**39 Oak Avenue  
Ickenham  
UB10 8LR**

## **PLANNING STATEMENT**

*Erection of a replacement dwellinghouse*

- 1.1 This application follows a recent pre-application submission (LPA ref: 321/PRC/2021/186) in which the council gave their feedback in a letter of 18<sup>th</sup> October 2021.

## FIRST FLOOR PLAN

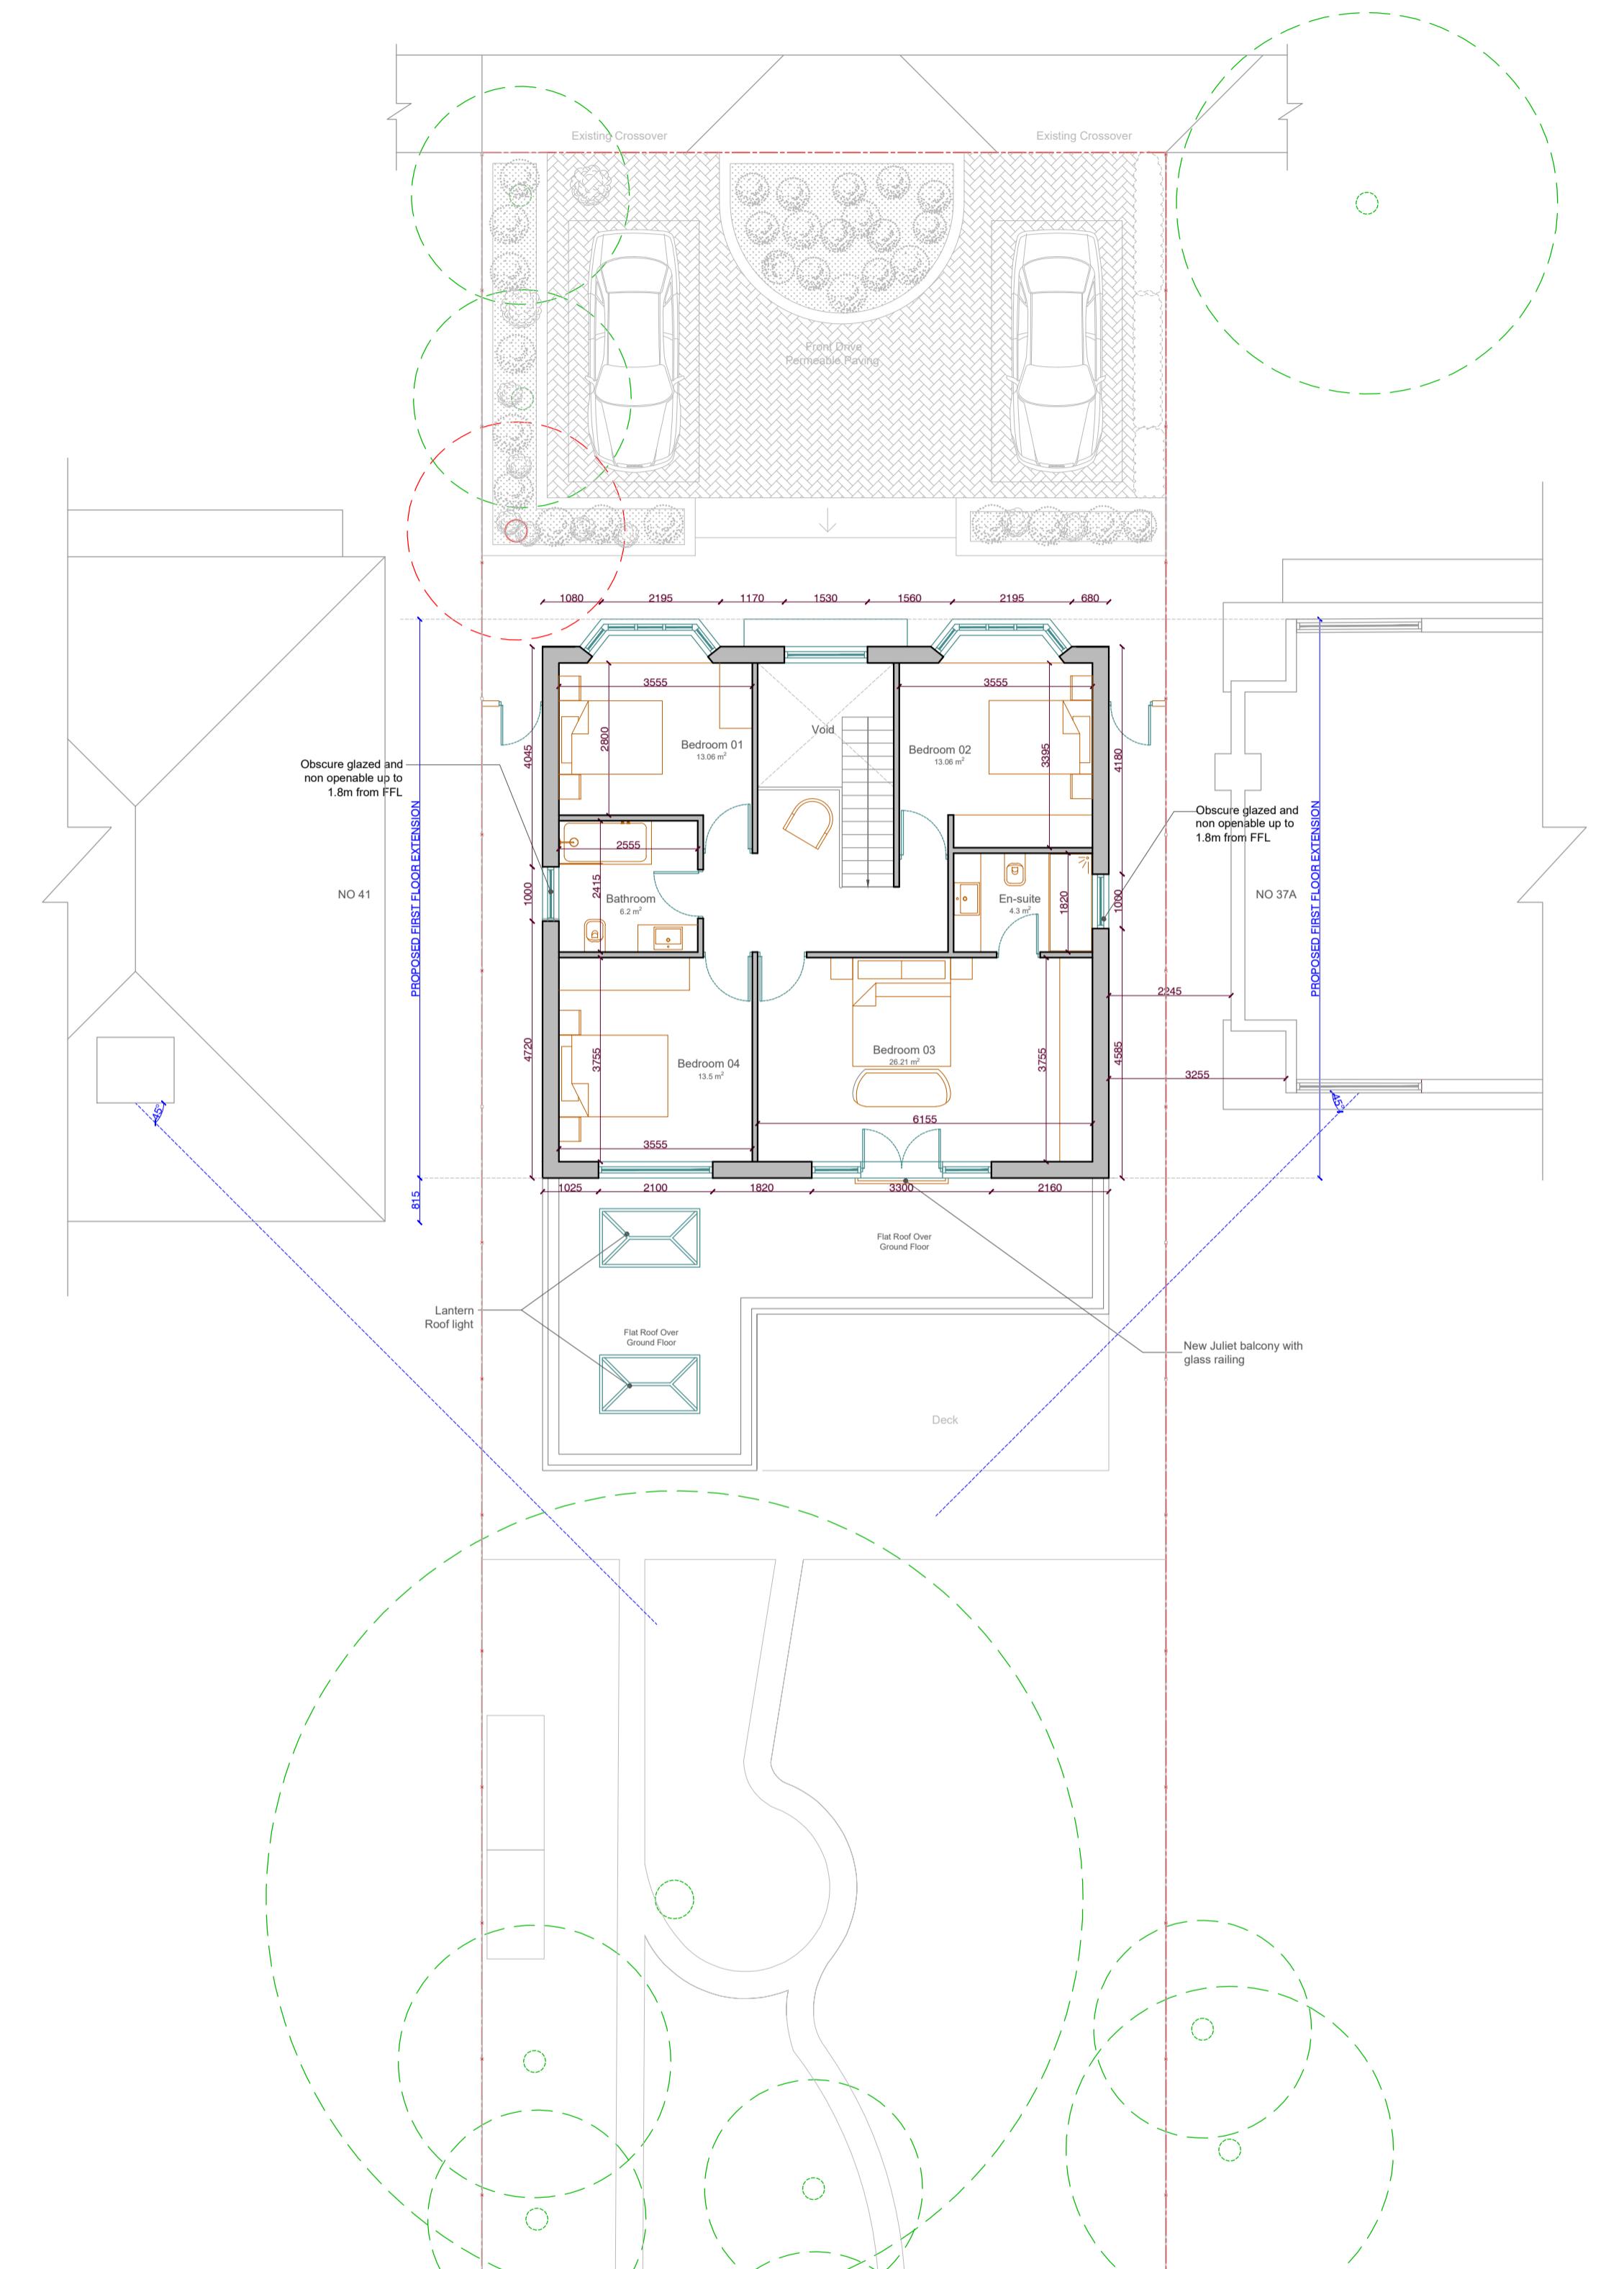
- 3.3 The council's pre-application comments were also concerned with the rear building line and how this would impact on the upper floor windows of the neighbouring properties on either side. The pre-application letter stated that:  
*'the rear building line would need to be reduced to overcome the harm caused to the living conditions of the occupiers of Nos. 37a and 41 Oak Avenue.' 45-degree test only relates to daylight and given position of dormers at 37a and 41, there will be unacceptable impression of enclosure which would be overbearing for these neighbouring occupiers. Also the outlook from these dormers would be severely undermined. Instead, it is strongly recommended that the depth of the proposed dwelling is reduced so that its*

*two-storey rear building line does not project beyond the rear dormer at no.37a (this would require a 1.6 metre depth reduction.'*

3.4 However, a detailed analysis of the relationship with no.37a and no.41 Oak Avenue shows that there will be no impact to these neighbours in terms of loss of outlook or with regard to creating a sense of enclosure and this is presented below.

3.8 The proposed first floor plan shows that the edge of the proposed first floor flank wall will be 3.2 metres away from the edge of the dormer at no.37a and that there is a very good separation distance between the first floor of the proposed dwelling and no.37a's rear dormer.

3.9 Most significantly, the image above shows a 45-degree line drawn from the rear dormer window of no.37a and it is clear that even if this line were moved to edge of this window (closest to the application site) that the proposed first floor would not break this line and that there is clearly no loss of outlook to this window and nor will it suffer from a sense of enclosure. The proposed rear building line will not be readily visible from the rear dormer window of no.37a and will therefore have little to no impact on this neighbour. It has therefore been demonstrated that the proposed first floor building line will not adversely affect the amenities of the first floor rear windows of no.37a Oak Avenue.

ROOF PLAN

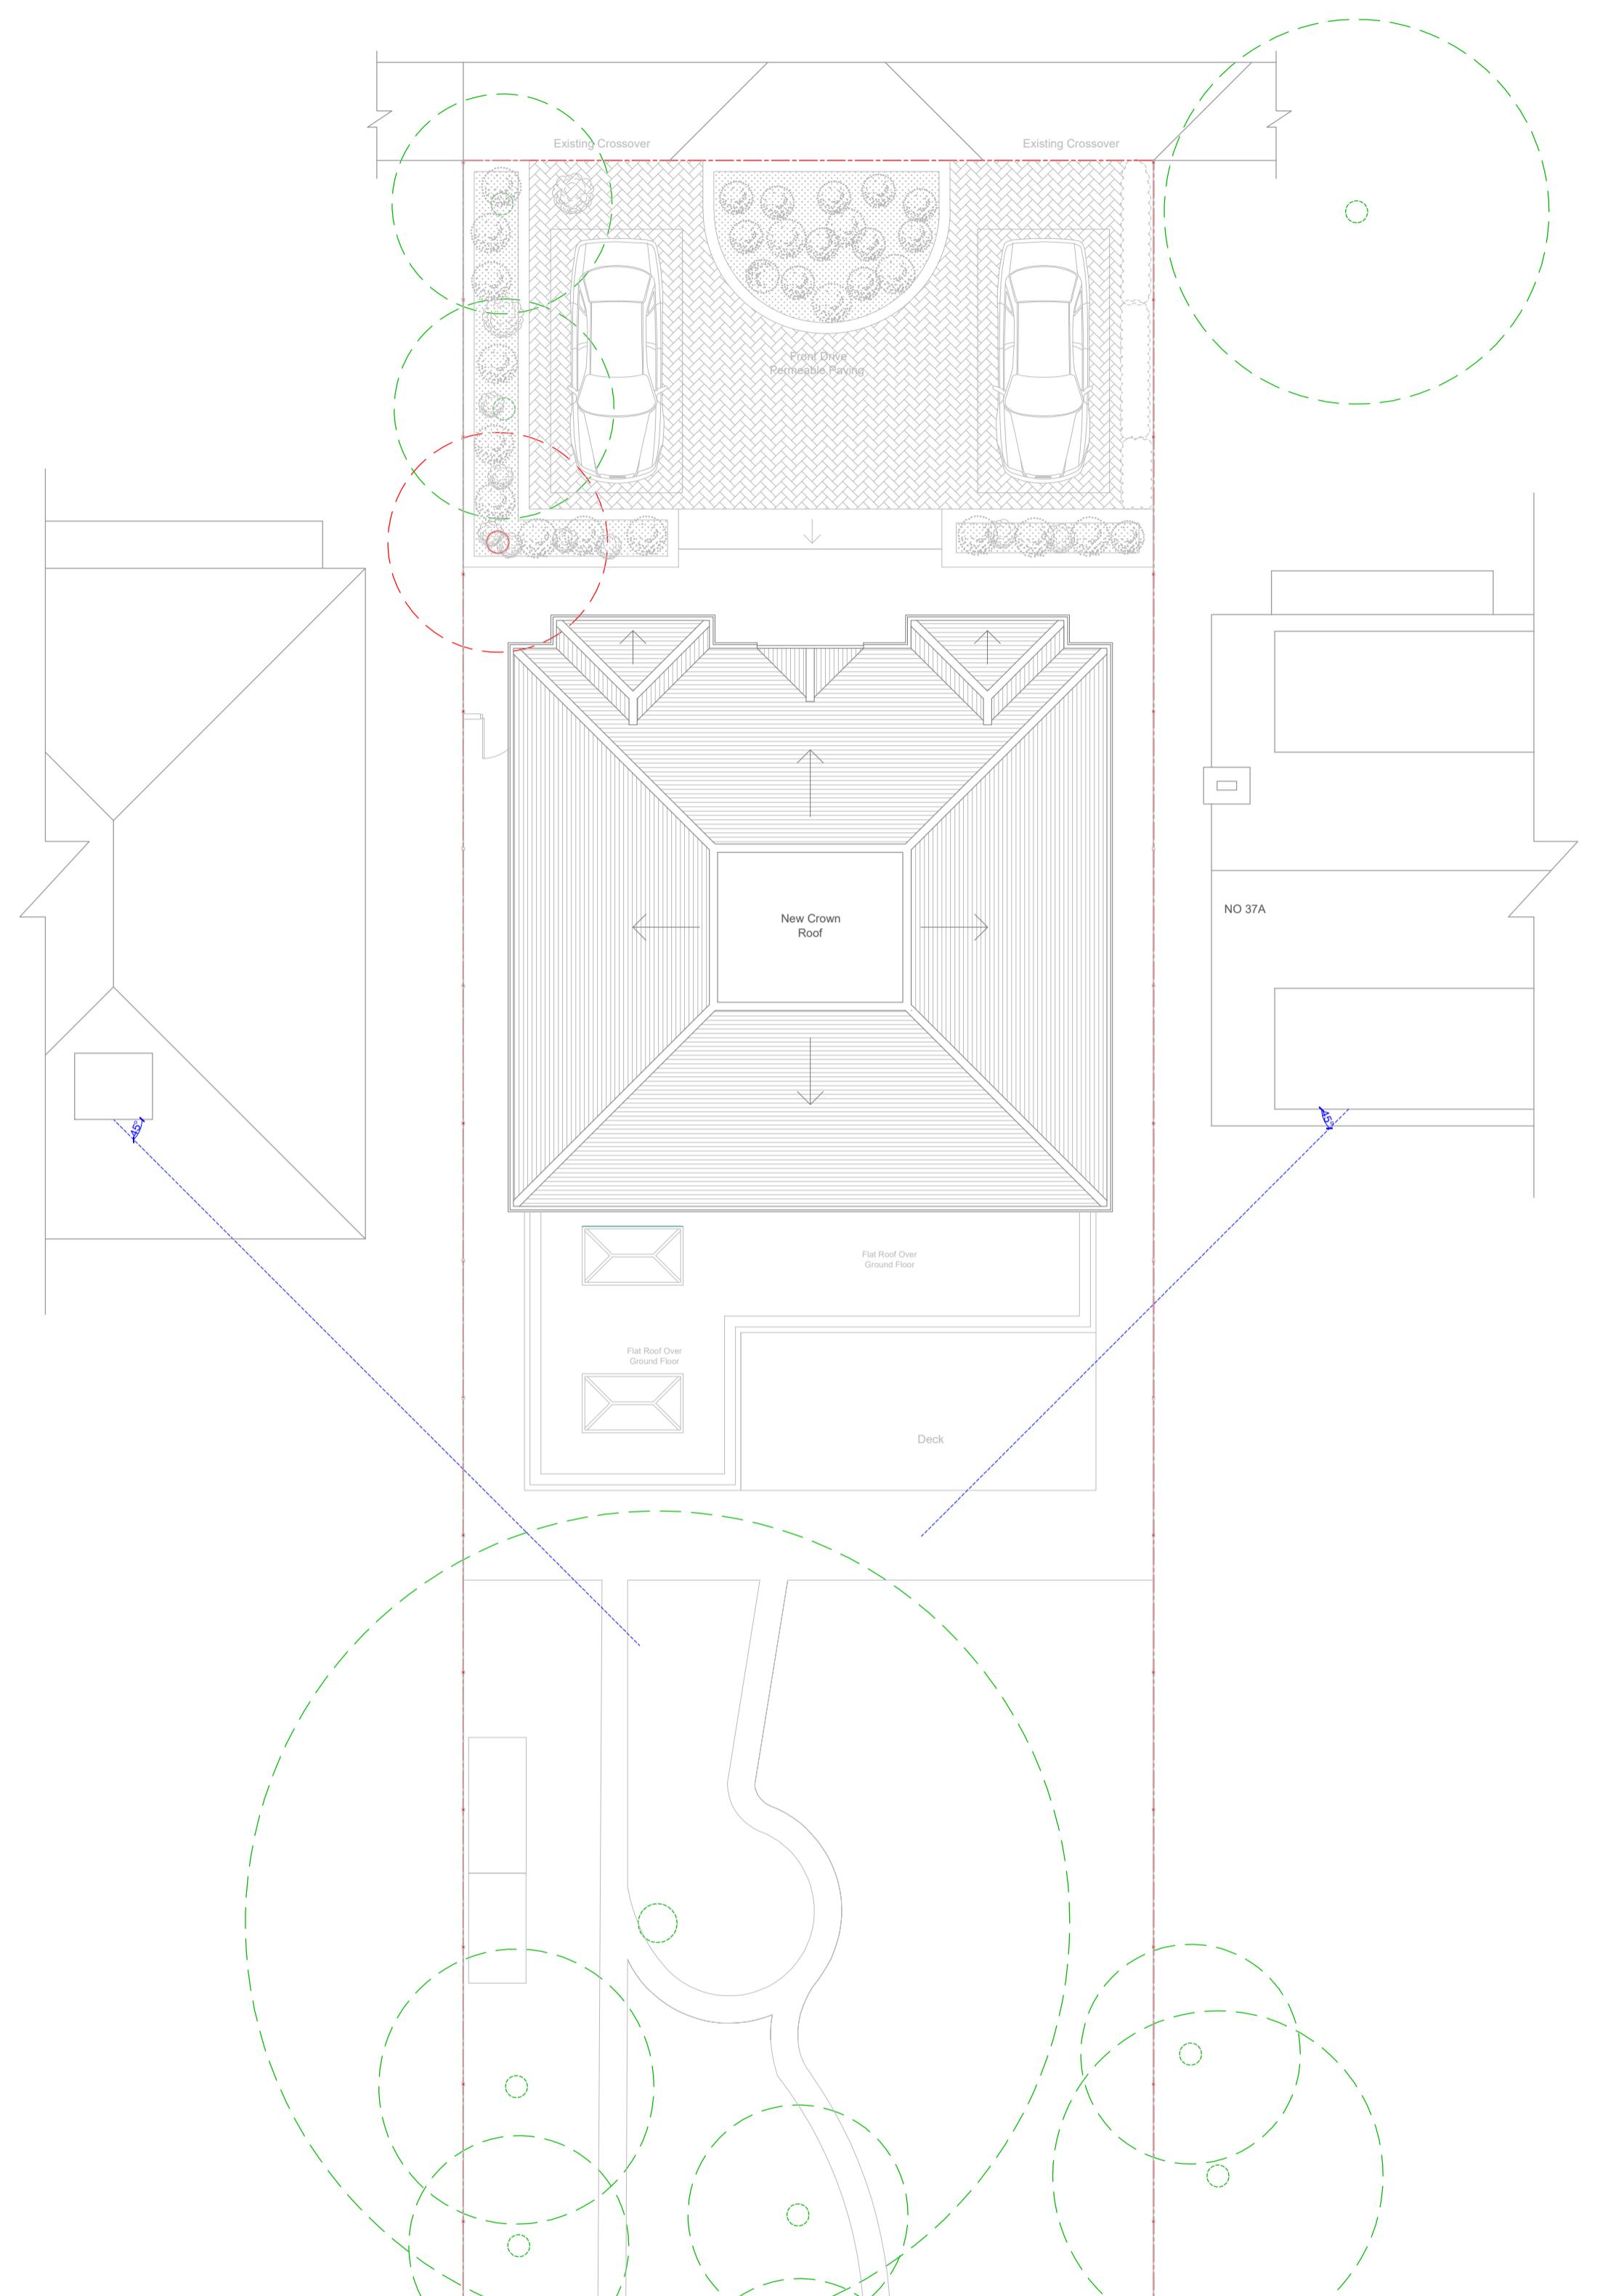
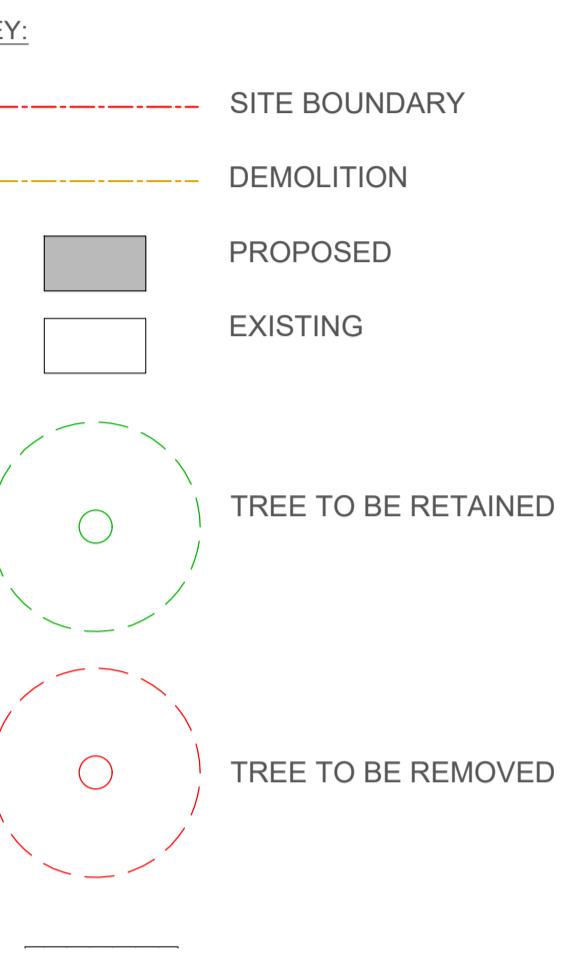
- 2.1 This council's pre-application response was supportive of the design concept of the replacement dwelling but requested that amendments be made to the crown roof profile in that '*the central flat roof element is reduced to resemble the appearance of the crown roof profile at no.38 Oak Avenue.*'
- 2.2 The crown roof profile has been amended in accordance with the council's request and this is demonstrated in Fig.1 below.

SIDE ELEVATIONS (1/2)

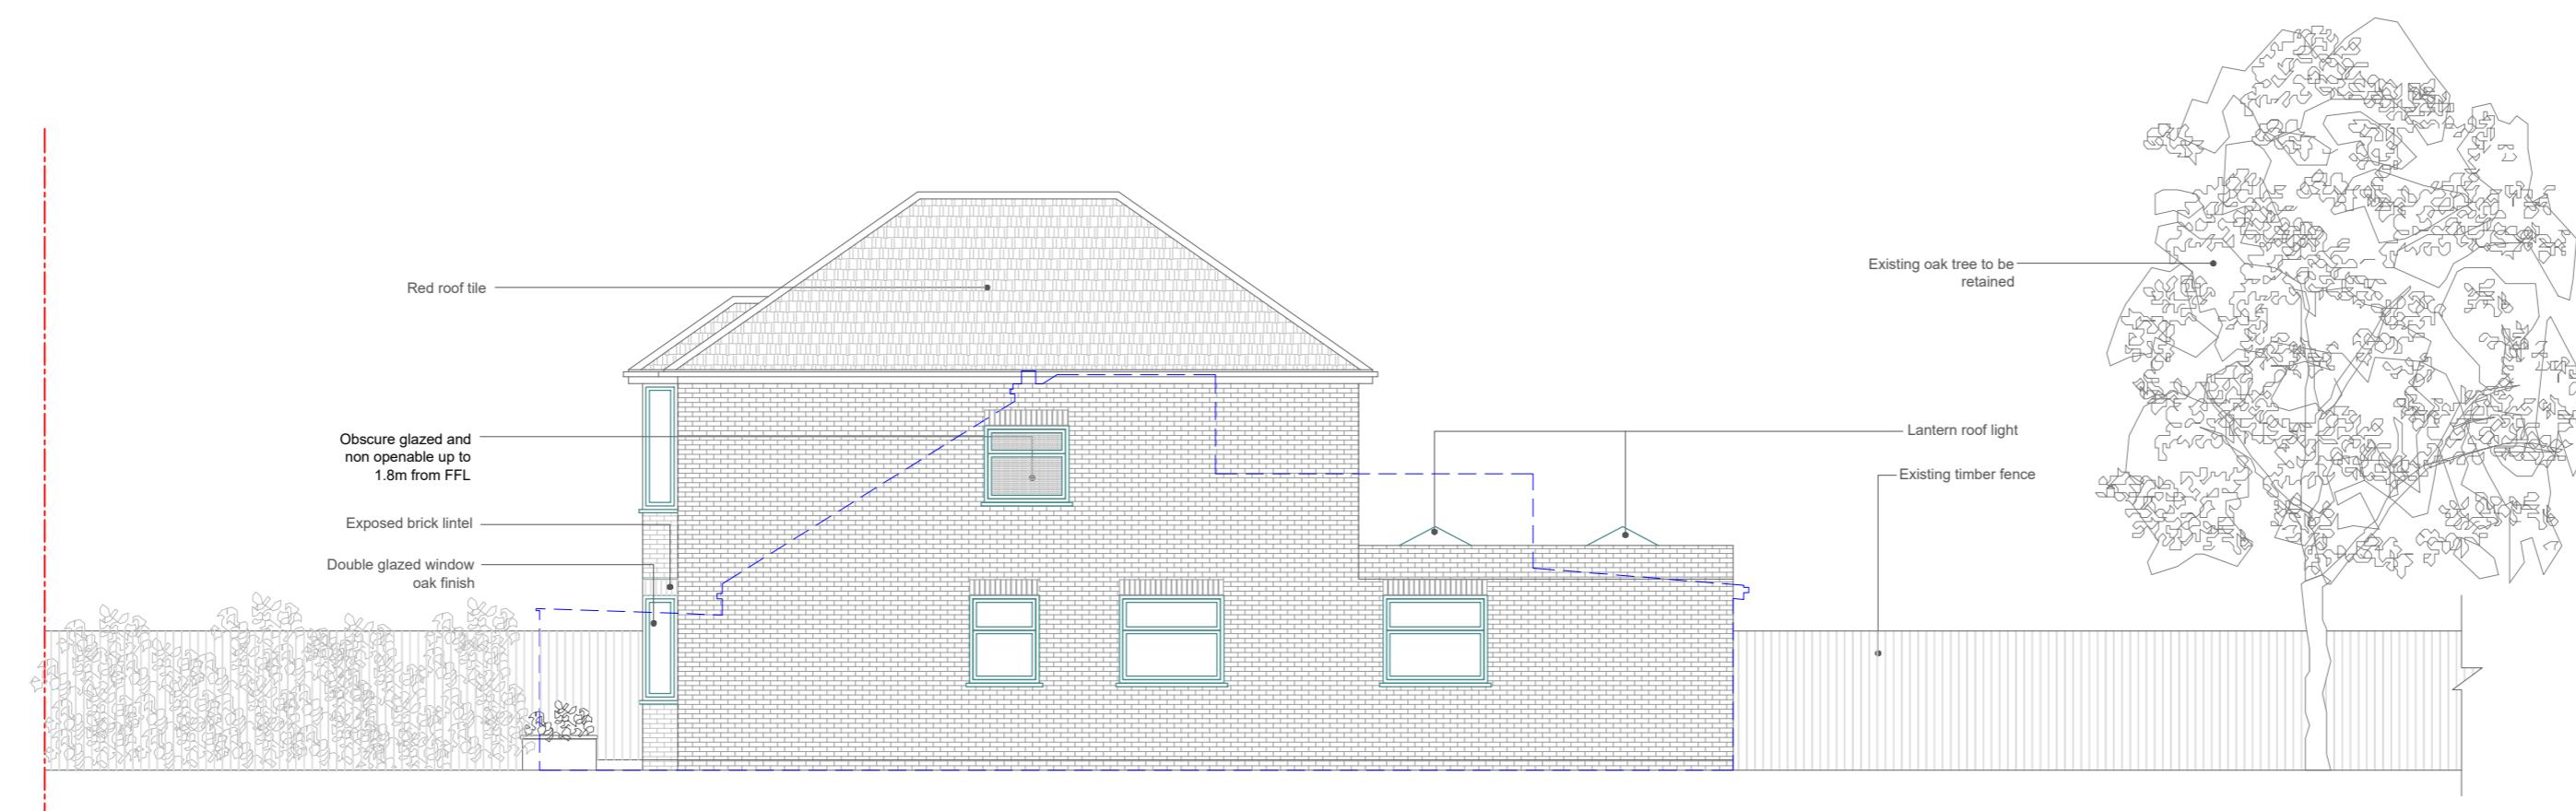
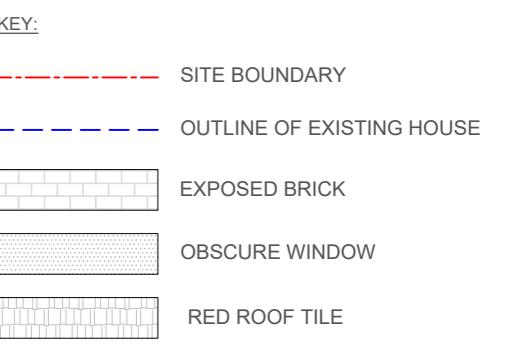
3.21 The final request from the planners in relation to residential amenity was that the side elevations demonstrate that the ground floor and first floor bathroom windows be obscure glazed and non-opening up to 1.8 metres above finished floor level and this annotation has now been added to the proposed drawings.
